**KIRKLEES METROPOLITAN COUNCIL
INVESTMENT & REGENERATION SERVICE**

DELEGATED DECISION TO DETERMINE PLANNING APPLICATIONS

| Reference No: | 2024/62/91199/W |

DECISION – Full Planning Permission – Refuse

SITE PLAN Scale 1:100 0 5m 10m

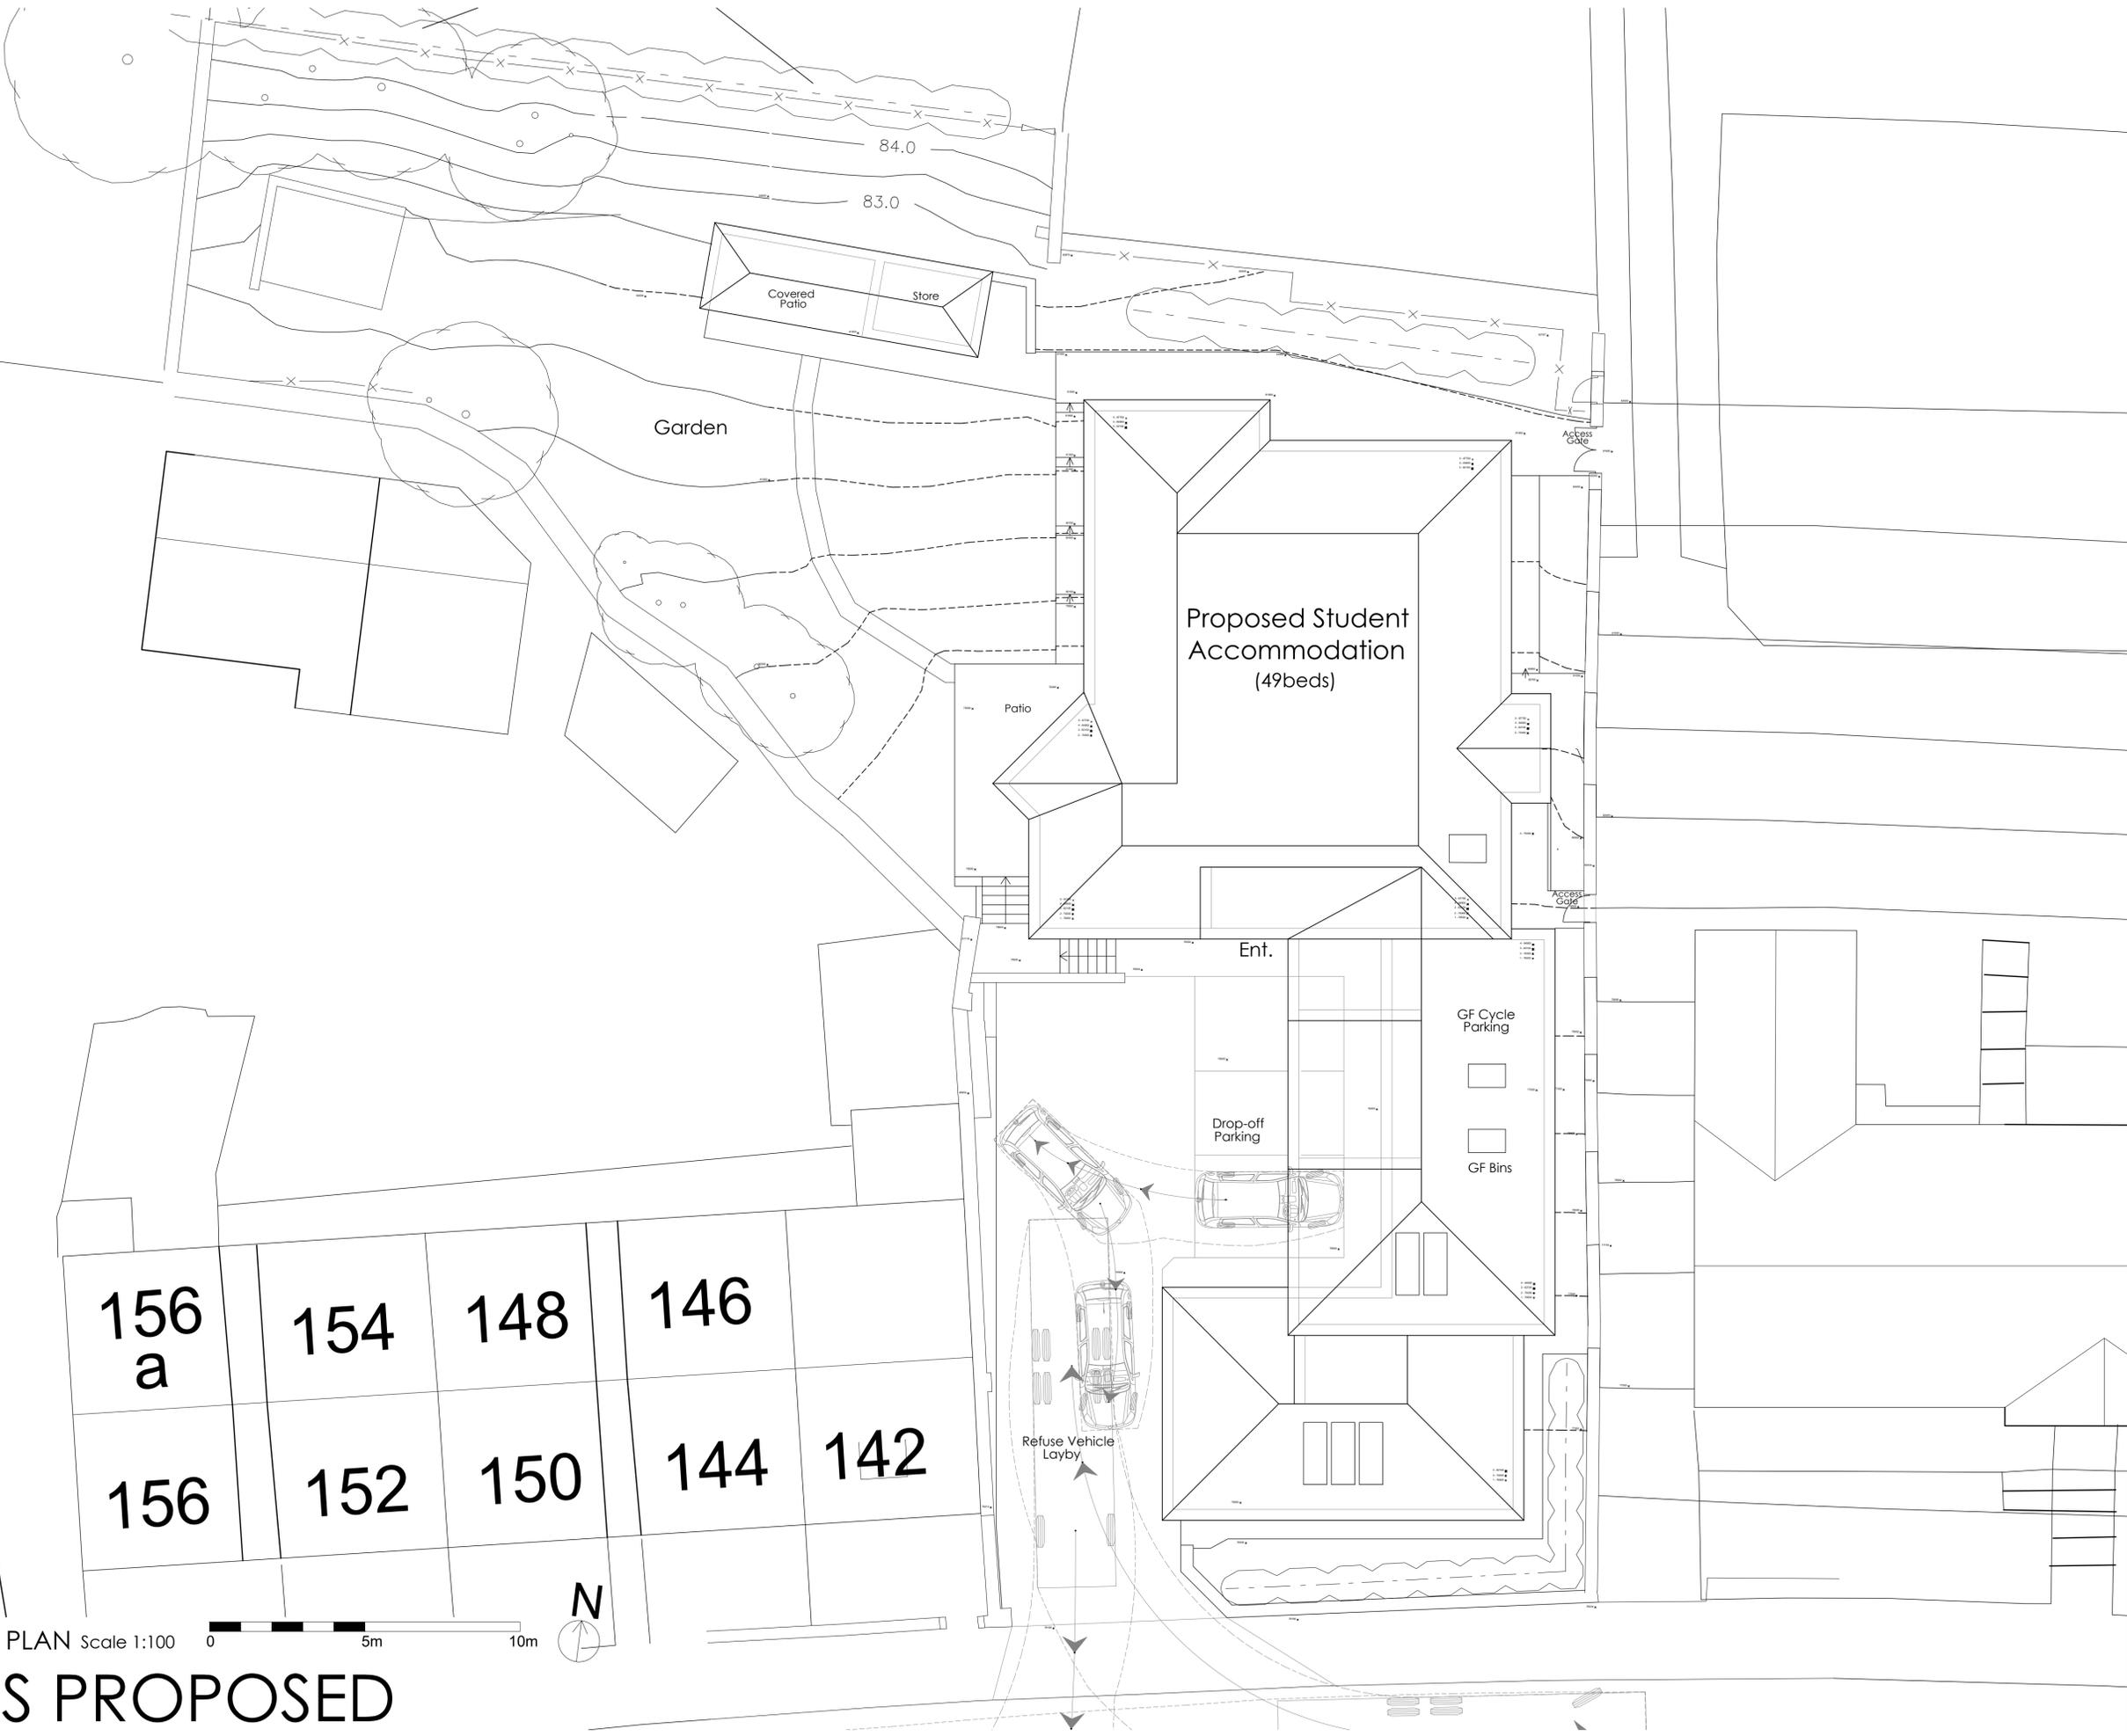
KC Highway DM: The proposal would provide unacceptable servicing arrangements, with reversing in and out of the site at this location being a non-starter. Internal turning would therefore be required which cannot be achieved with the size of the development proposed.

The three spaces are acceptable and they all scale to 2.4m x 4.8m. However, a swept path analysis would be required to show that vehicles can turn on site, so they enter and exit the site in forward gear for highway safety reasons (the adopted highway is a classified main distributor road, A62, and as such we wouldn't want to see any reversing manoeuvres either on or off the road).

GA ELEVATIONS
 AS PROPOSED

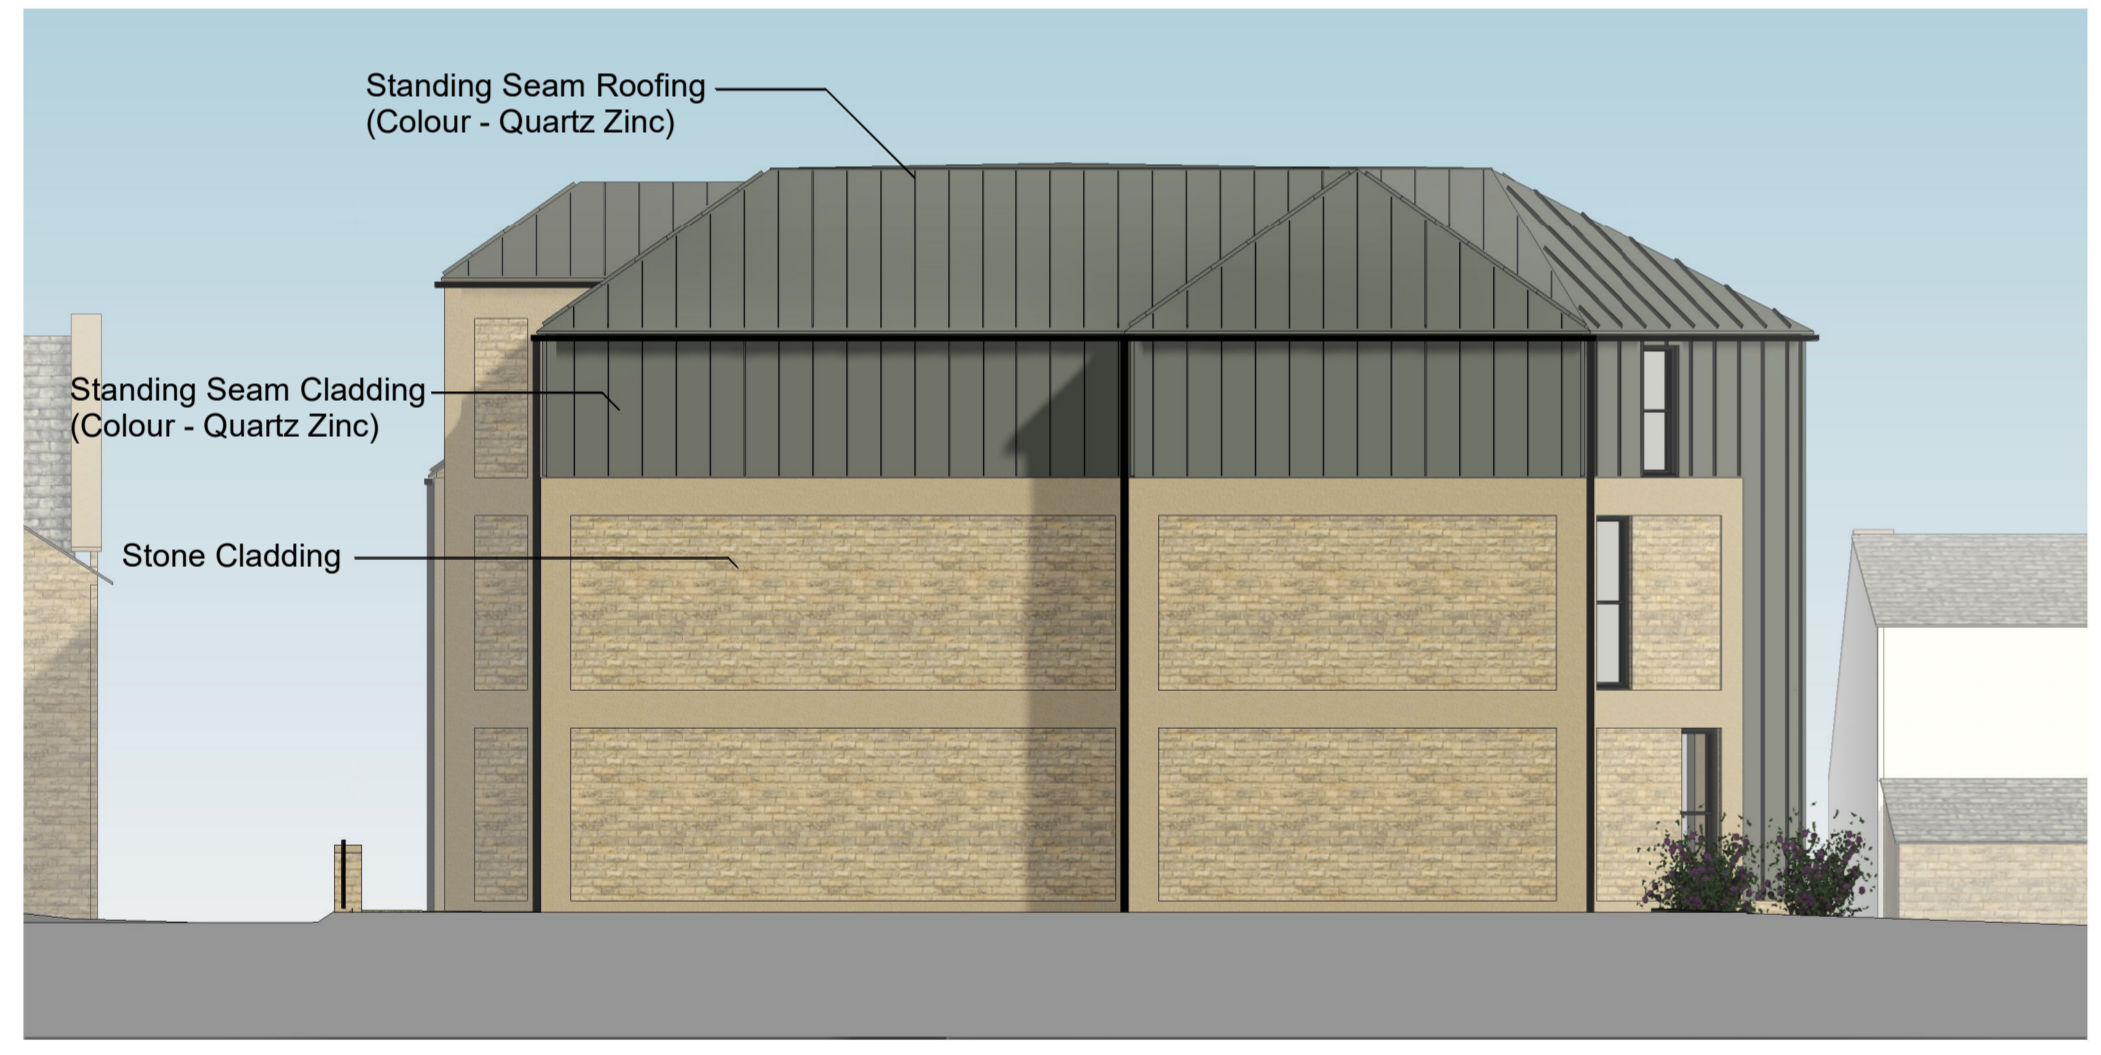
I have reviewed the application with Management and unfortunately, we cannot support the scheme as submitted. We have significant concerns regarding visual amenity and impact on heritage assets, particularly regarding the design, size and scale of the building. The development is also considered to appear incongruous within the site and the wider street scene.

of the building would make it appear incongruous within the street scene. Its overall height and massing would result in an oppressive and overbearing design, the effect of which is clearly demonstrated on the submitted sections plan. The proposed elevational treatments, and the location of the building's entrance (concealed away from the street frontage) would further exacerbate the problem of the proposed development relating poorly to its context and appearing incongruous.

Design and heritage – The revised proposal from the previous submission only appears to be minor. Officers are not averse to the increase in the width of the front section of the building looking onto Manchester Road. However, we do think that the fenestration would need to be rationalised to be more traditional and reflect the character of the street scene along Manchester Road.

The proposed development would near enough fill the plot and would also extend further back. The development would entirely interrupt the views and appreciation of Spring Lodge and 14-15 Woodthorpe Lodge and would have a significantly harmful impact on their setting and the historic grounds associated with Spring Lodge.

Regarding the listed buildings 160, 162 and 164 Manchester Road, while these are detached from the site, they are experienced off Manchester Road when looking along the road from the west and the east. The proposed development is of a considerably greater height and scale than the existing surrounding development. The development would be clearly visible in long views along the row of terraces. The submitted statement tries to set out that – with similar and contemporary materials, maintaining a strong continual eave line and simple façade with pitched roofs – the proposals reflect and respect the character and setting of the listed buildings. This subjective assessment is not accepted. While the building may make use of similar materials, the design elements are entirely incongruous and in no way reflect the character or setting, even in a contemporary style.

The proposals would cause harm to the setting of the listed buildings, introducing development which is entirely disproportionate in scale, height and design to the setting of the noted listed buildings and the character of the local area. There is not sufficient evidence or justification of benefits which would outweigh the harm. The proposals should either be withdrawn or refused.
